NOTICE OF APPEAL

Subject: January 13, 2020 Notice of SEPA Action
Mitigated Determination of Nonsignificance SE-19-000014
Issue by Kittitas County Community Services
Love's Travel Stops & Country Stores, Inc.

Proponent: Patryk Kowalczyk, Applicant
Nick Wheeler (SJC Alliance), Agent

DEVELOPED BASIN AREA MAP

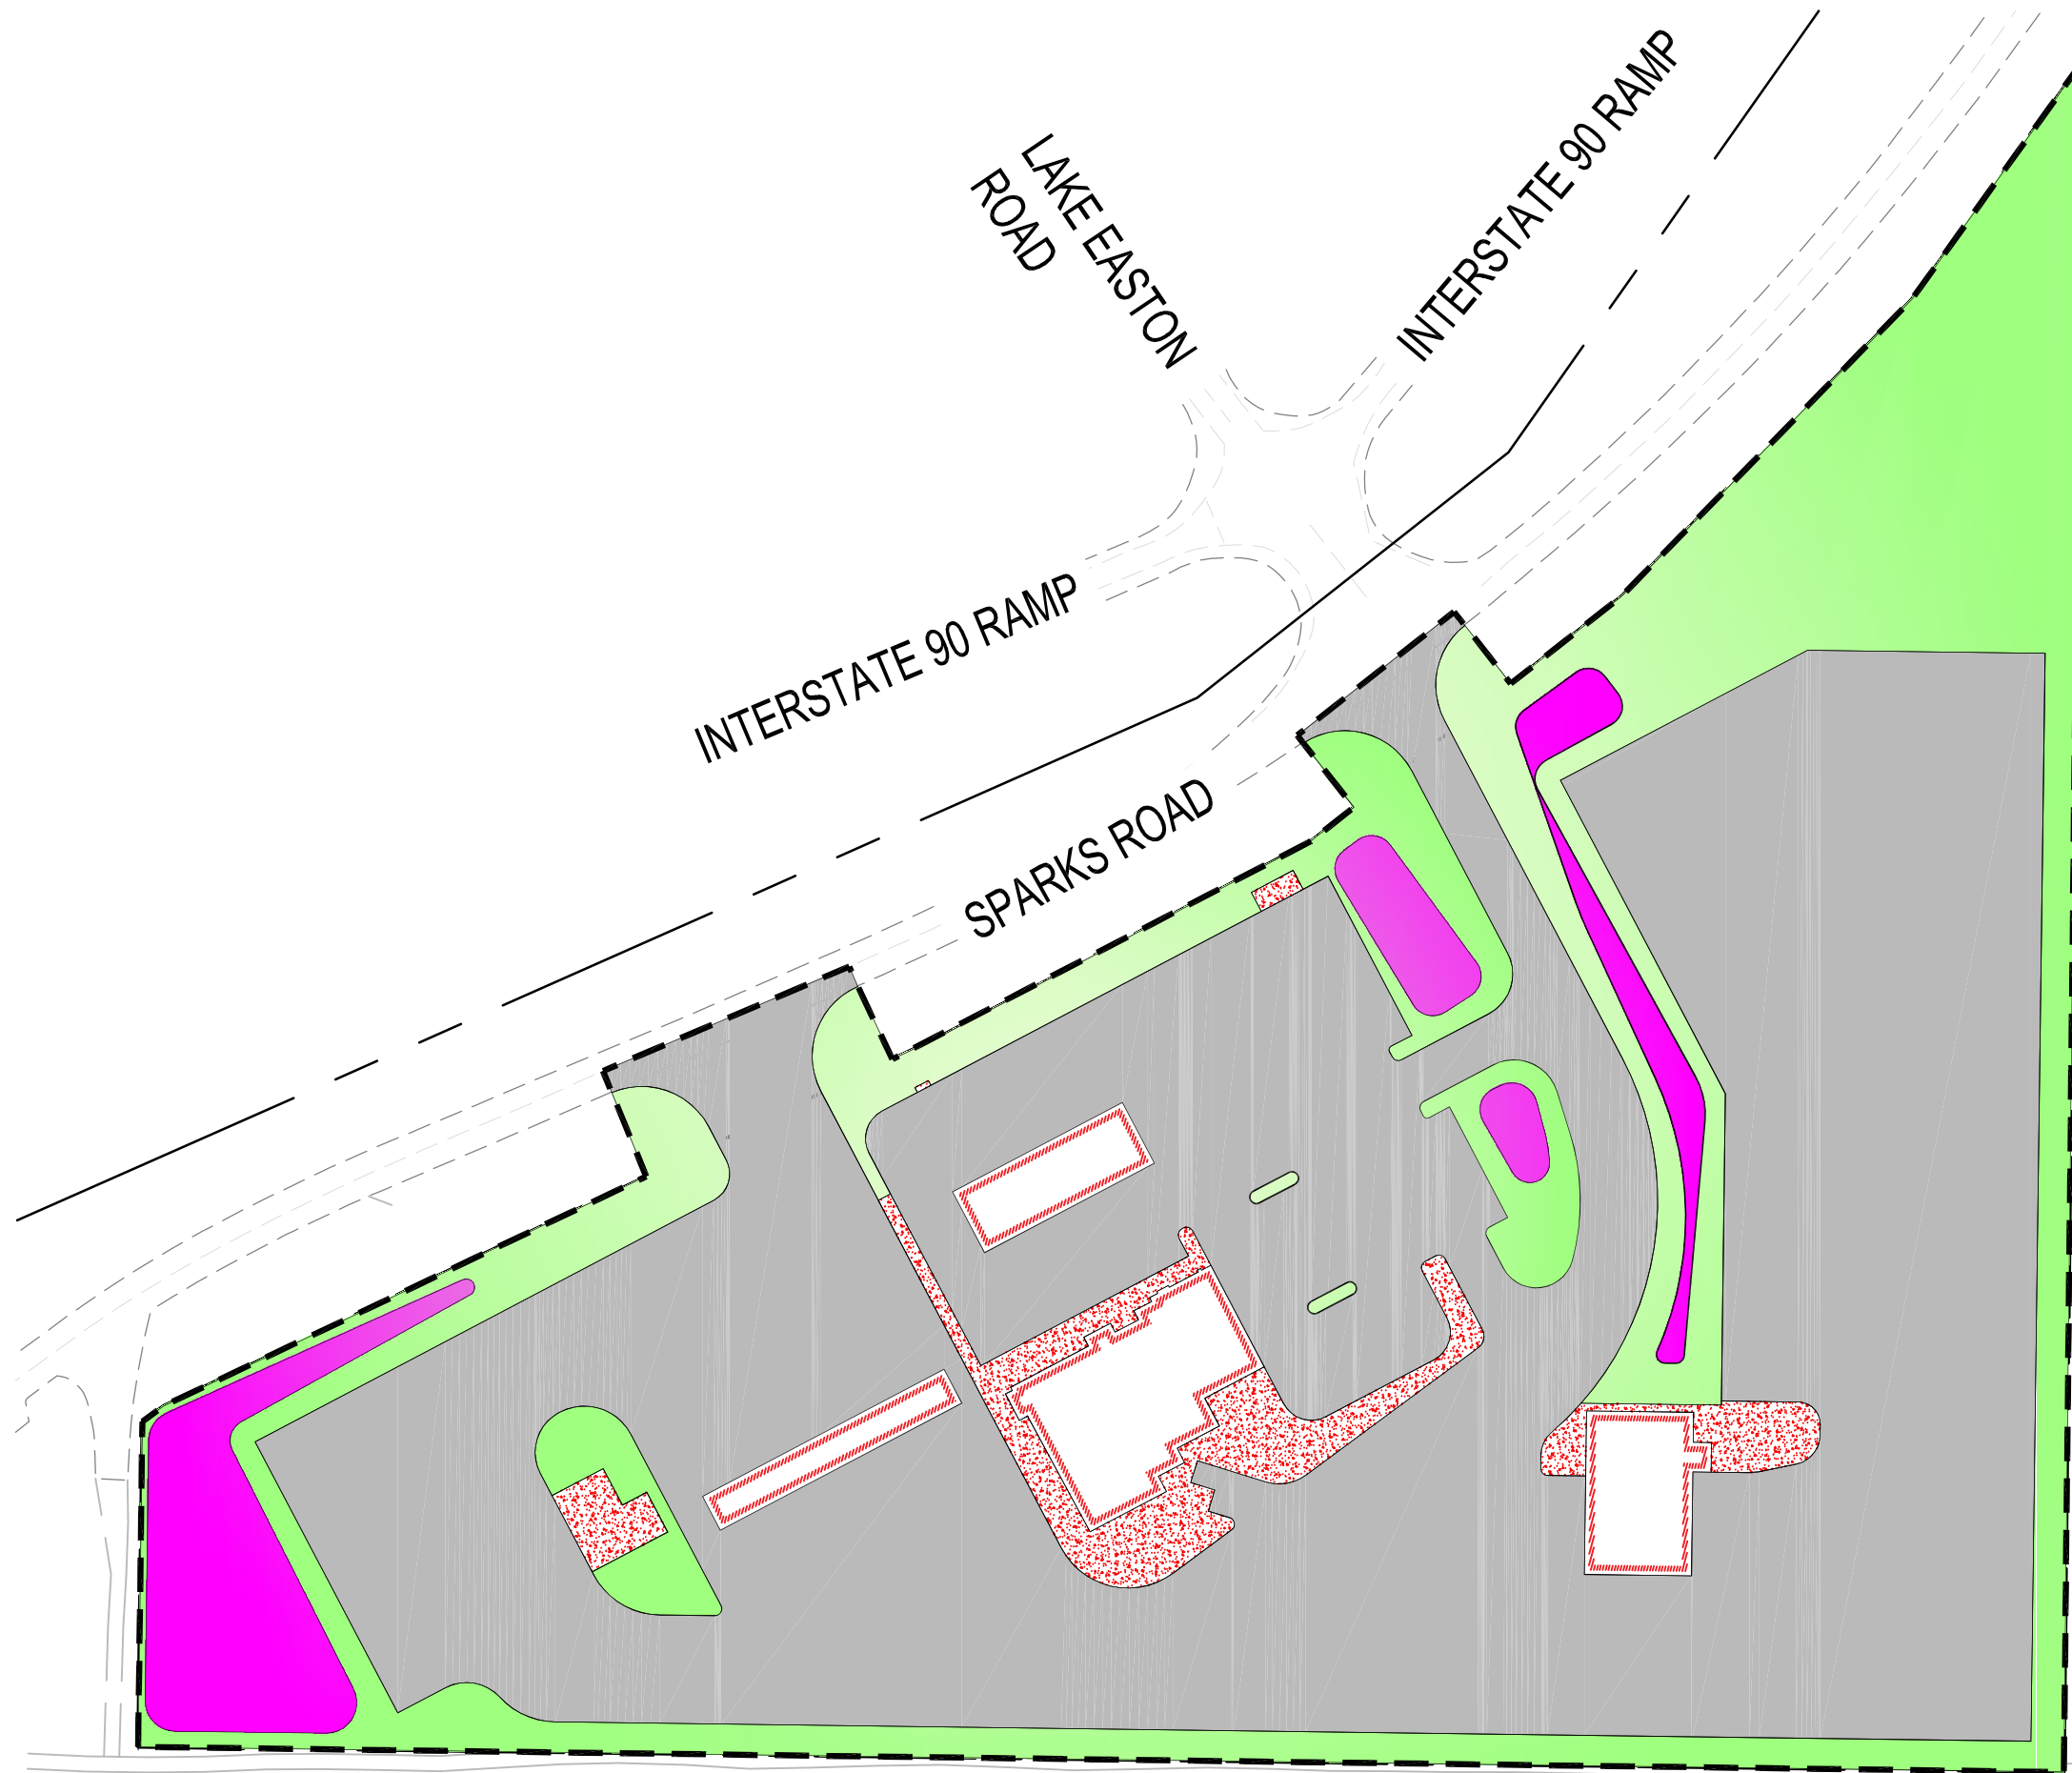
Kittitas County Code 17.15.070 Allowed Uses in Rural LAMRID Lands, limits allowed uses in Type 3 LAMRIDS to 30,000 square feet and limits impervious surfaces on lots larger than one acre to 1/3 of the lot. The SEPA Checklist submitted by the proponent on Page 3, B Environmental Elements g. indicates "Approximately 74% of the site will be covered with impervious surfaces after project completion." The proposed 74% impervious surface of 16.51 acres would be 12.2174 acres while the

maximum impervious area allowed by 17.15.070 would be 5.4483 acres. The proposed building area .74 acre (32,234.4 sq. ft.) as described on page 167 of the Preliminary Stormwater Plan alone would exceed the 30,000 square foot limitation in 17.15.070. (See attached Developed Basin Map)
